# Landscape\_V3.pdf Markup Summary

**Subject:** Cloud+  
**Page Index:** 1  
**Date:** 9/3/2019 4:51:50 PM  
**Author:** dsdruiuz  
**Color:** ■  
**Layer:**  
**Space:**  
**Page Label:** 1

LS.4

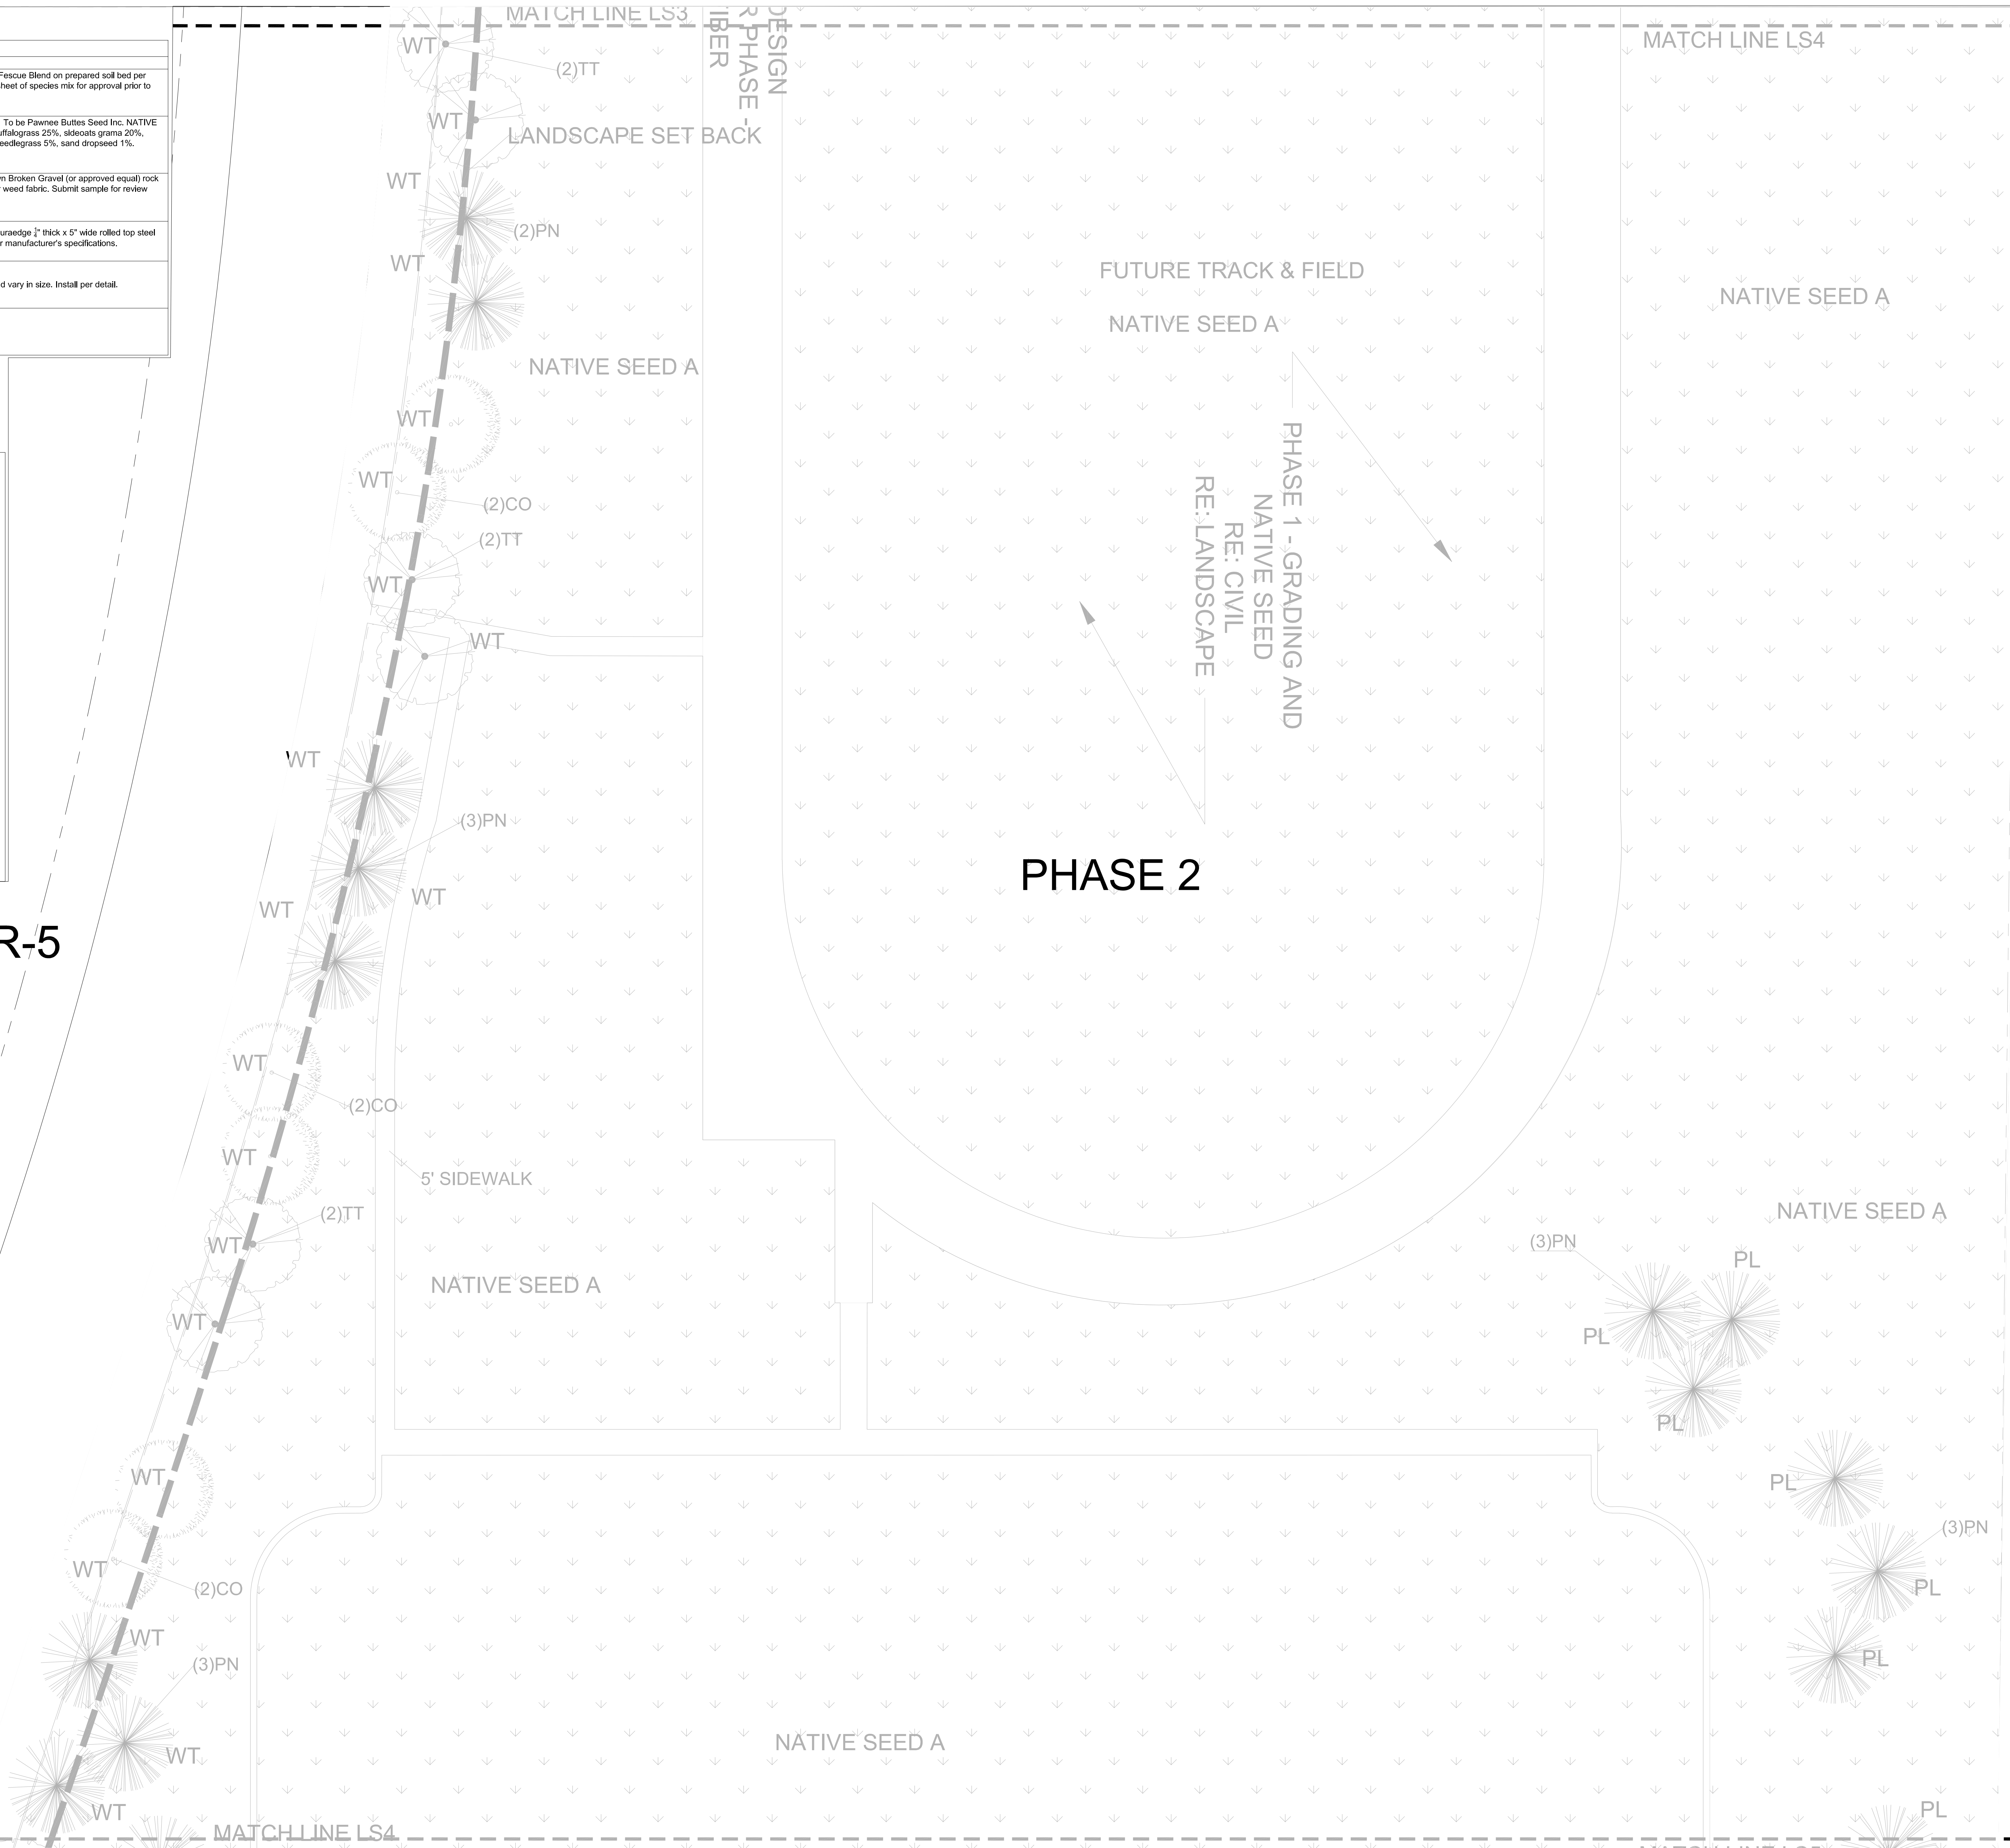
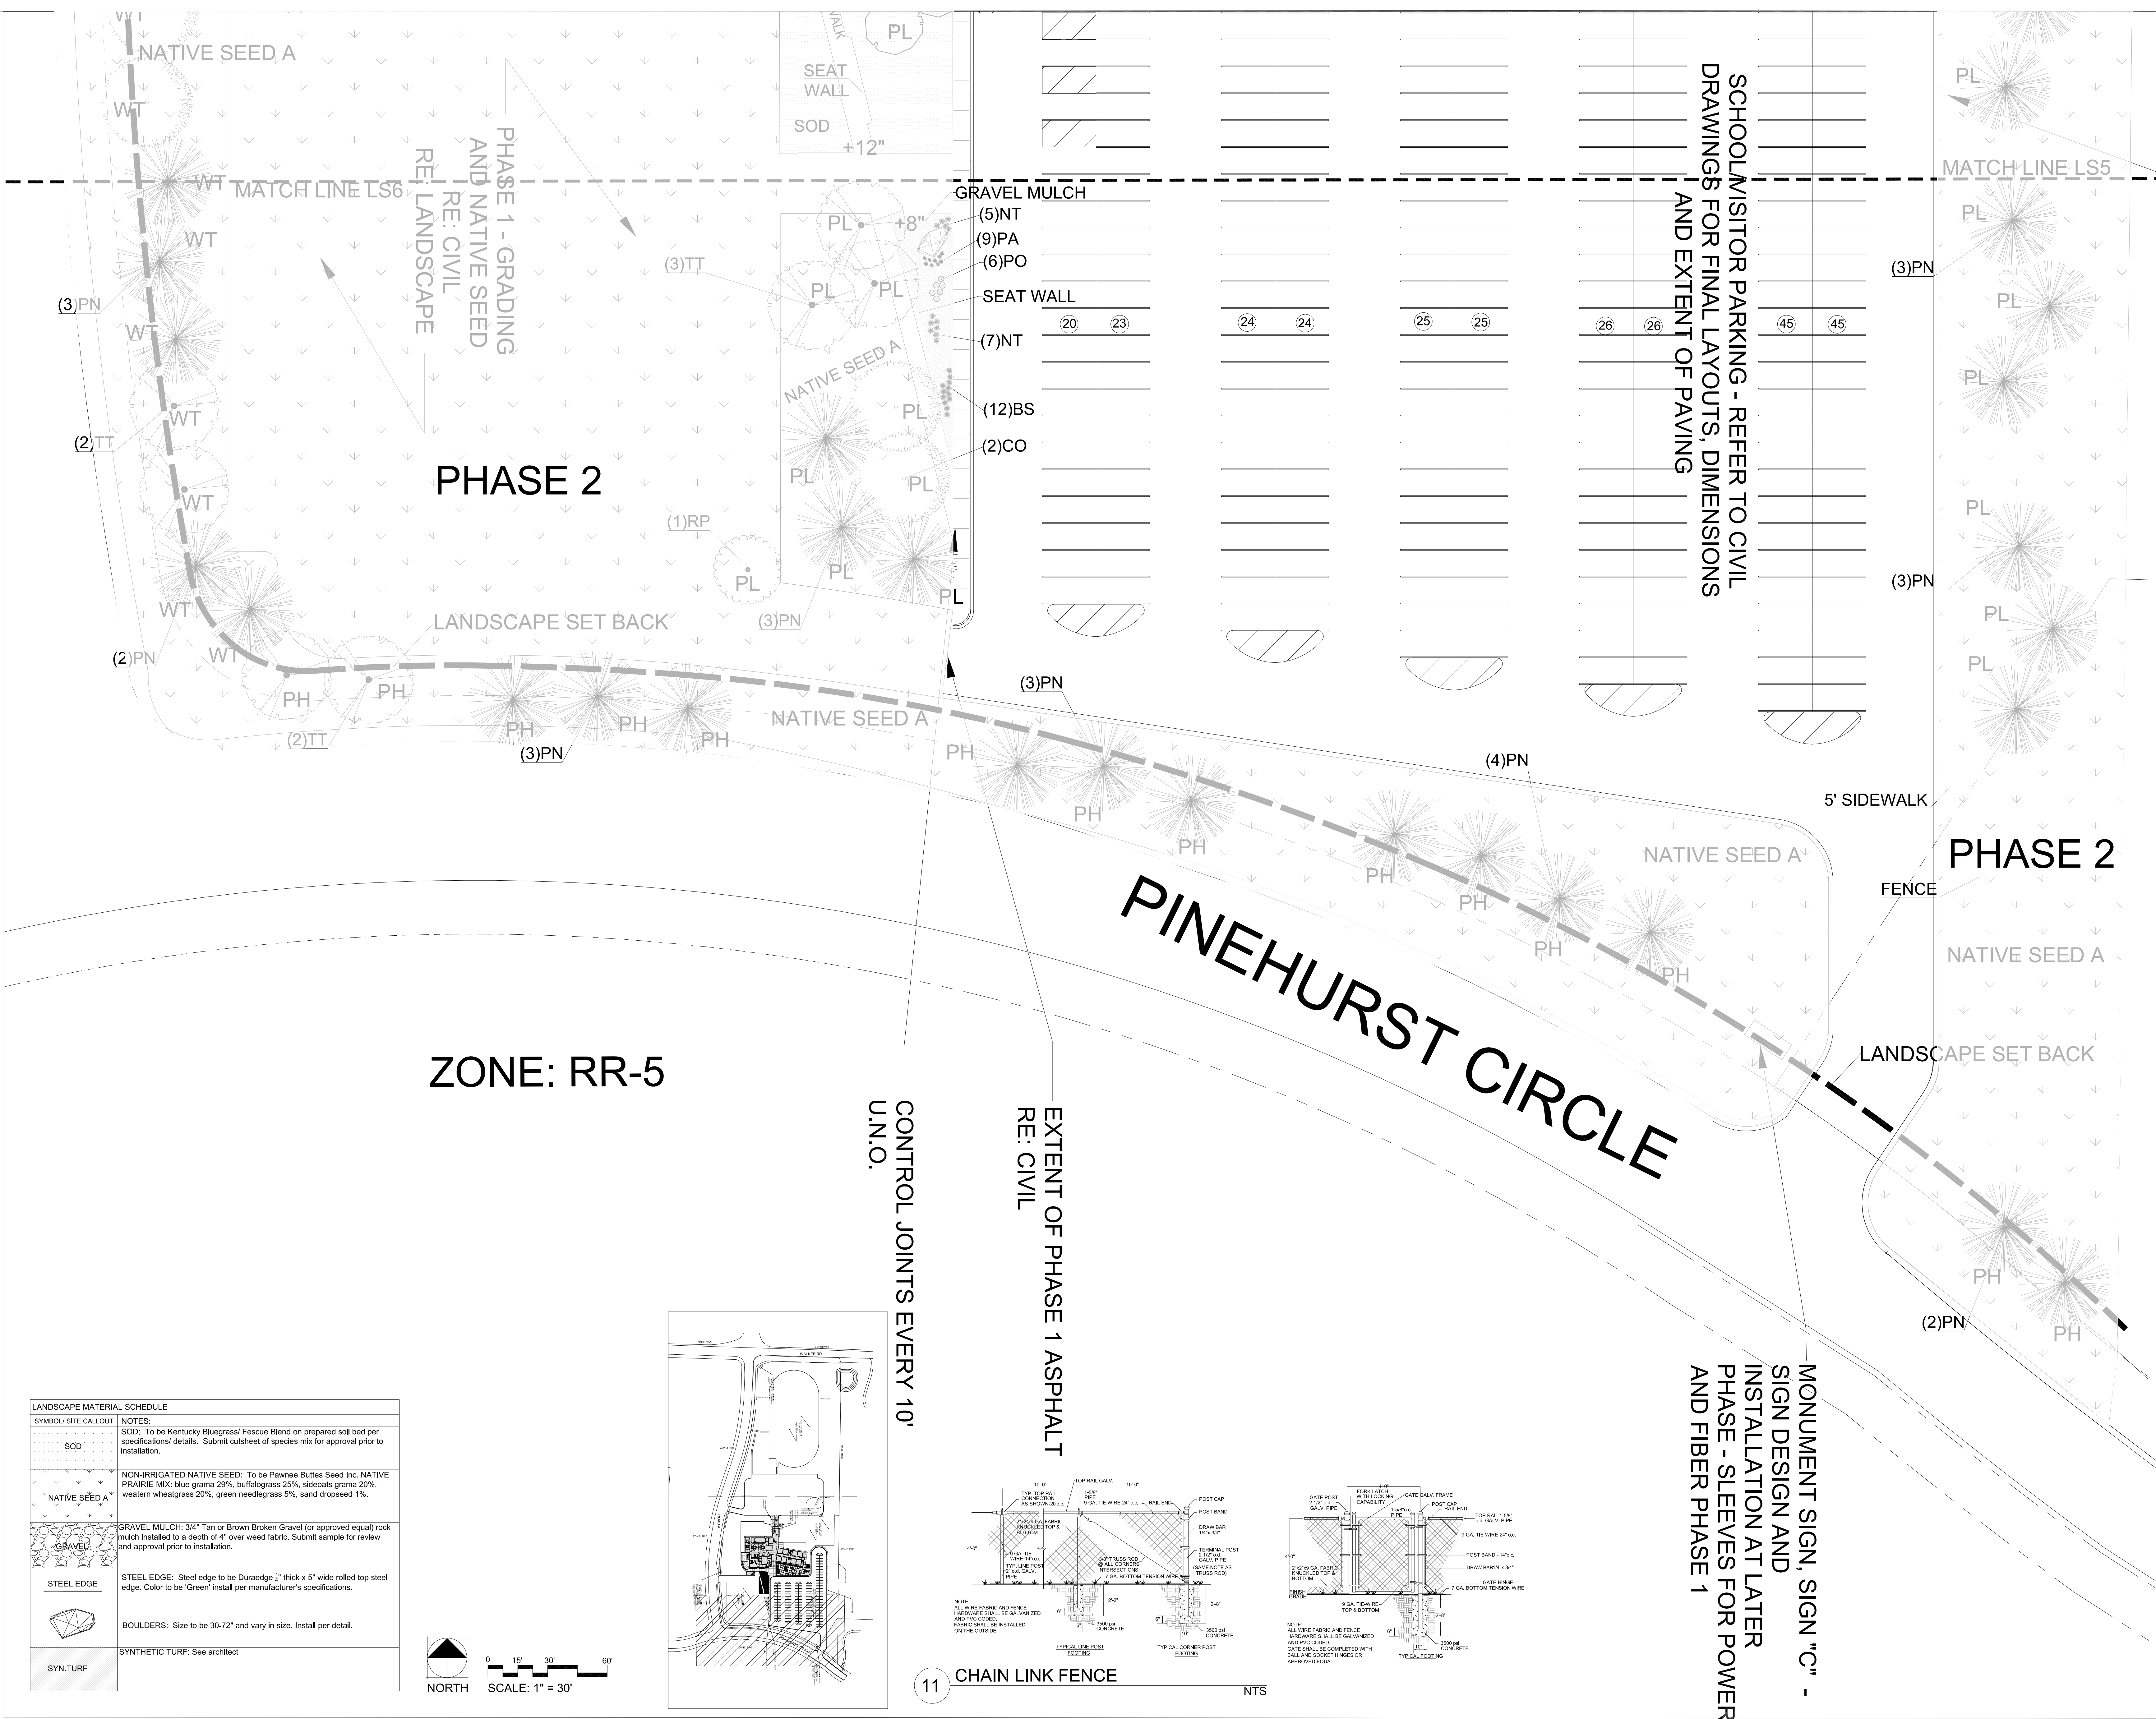
staff recommends additional plantings along the east side per requests by the adjacent neighborhood.

Isn't this plan for "Phase 2" (Phase 1B)? What is proposed?
